Application for a Non-Material Amendment Following a Grant of Planning Permission

51 Higher Compton Road Plymouth PL3 5HZ
PROPOSAL: Change of use of ground floor shop to 1no. flat (Class C3)
inc. extension to front bay window, plus hip to gable and
rear dormer to enlarge existing first floor flat

23/00973/Ful

DWG 2 of 3

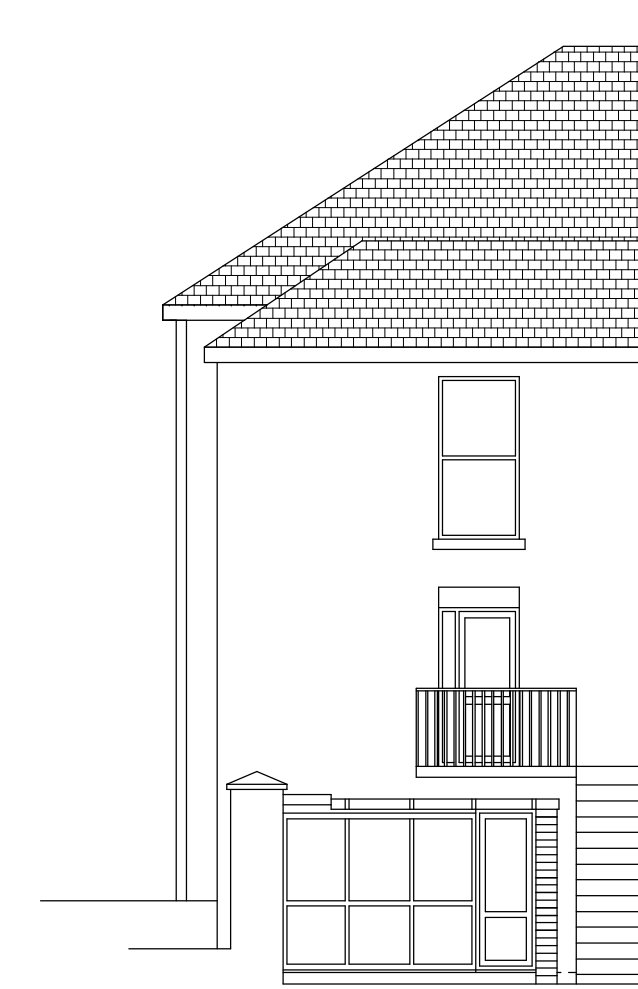
Removal of external staircase to rear and fitting of doors with juliet balcony to replace window in dormer

The removal of the stairs provides improved amenity for the lower ground floor flat
